Planning Application Ref: BN/90/19/T

Location: Land East of Toll Cottage, Lake Lane, Barnham, PO22 0AD

Description of works: Fell 1no. ash tree

Project		For	
Land at Lake Lane		Seaward Properties Ltd.	
Barnham		Date	Oct 2016
		Scale	1/500 @ A4 size
Drawing		Drawing number	1748-30F
		Studio Lack Architecture	
		17 Beech Avenue, Chichester	
		01243 782686 nicholas.lack@live.com

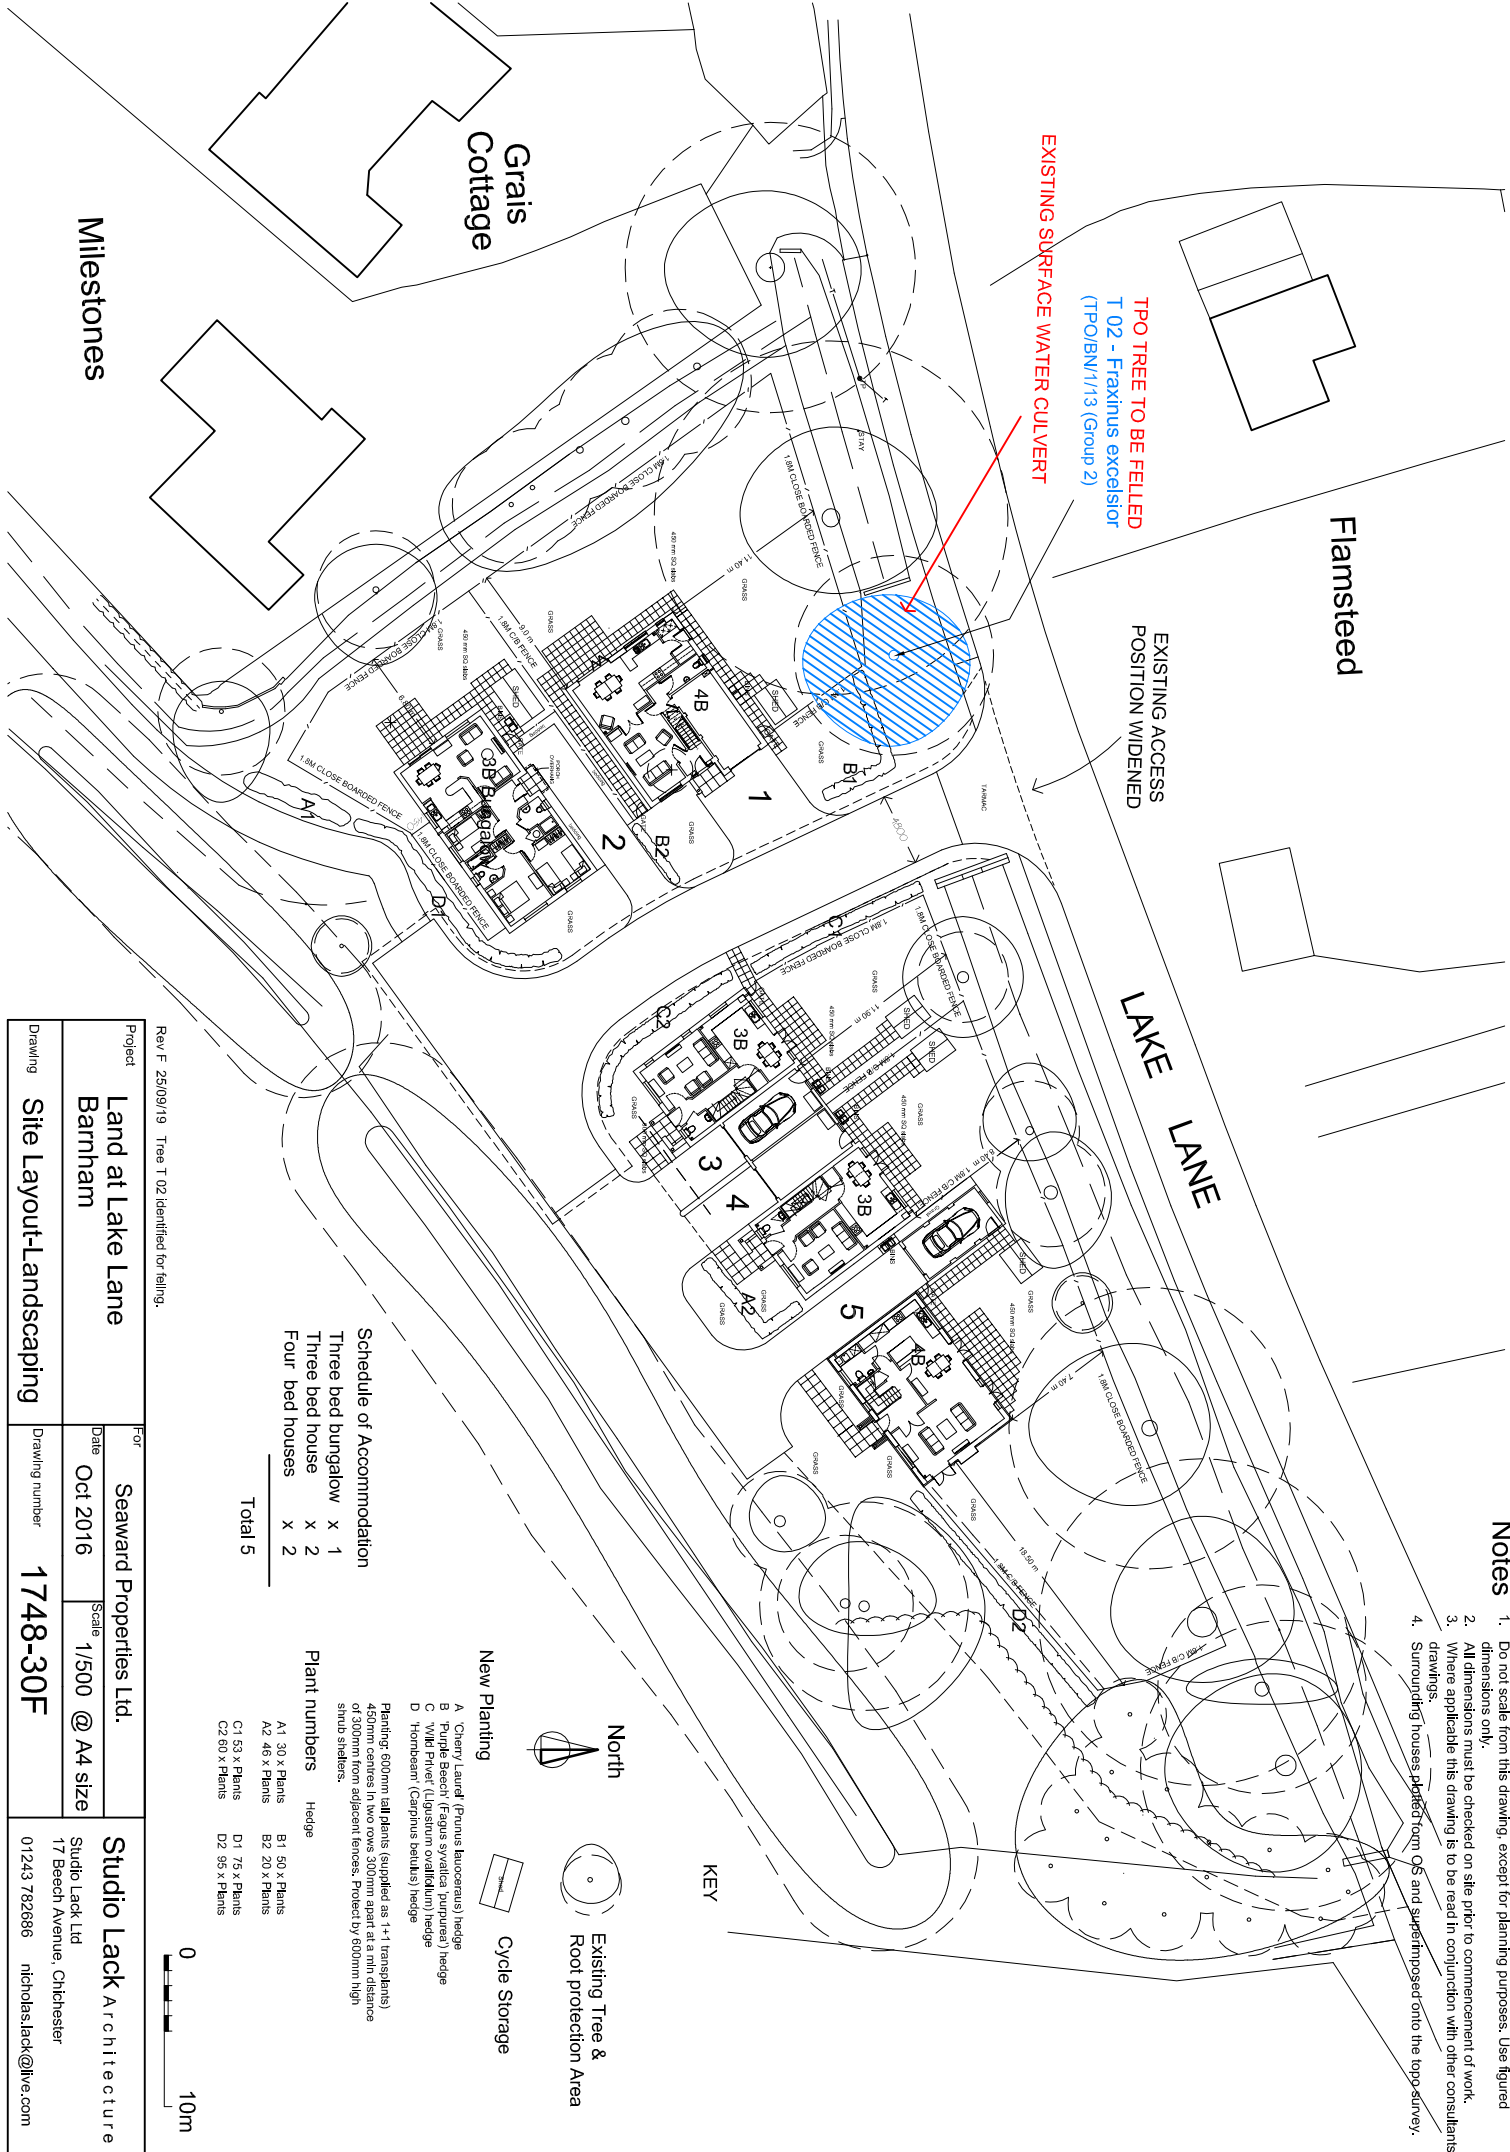
- This tree appears to be outwardly healthy and stable with a relatively unmodified and attractive crown profile. It is probably self-set, having established itself adjacent a strategically important culvert.
- It is prominent roadside and contributes to the tree-lined character of the lane, although subordinate to the mature lime and oak to its west.
- Arun DC Engineer (drainage) supports the removal of this tree to facilitate drainage enhancement work and safeguard long-term integrity of those apparatus.
- The applicant has requested that no condition be applied to any permission in respect of replacement tree planting.

- The work proposed is necessary to ensure successful enhancement and long-term integrity of strategically important drainage infrastructure. The tree of relatively low amenity value, such that an alternative engineering solution is not justified.
- There will be no significant loss of public amenity on completion of the proposed works.
- There is adequate density of trees with even age-class distribution, such that the removal of the ash tree will not be too keenly felt. As such, there is no requirement for a condition to secure a replacement tree at this location.

- I recommend **CONSENT** for this application.
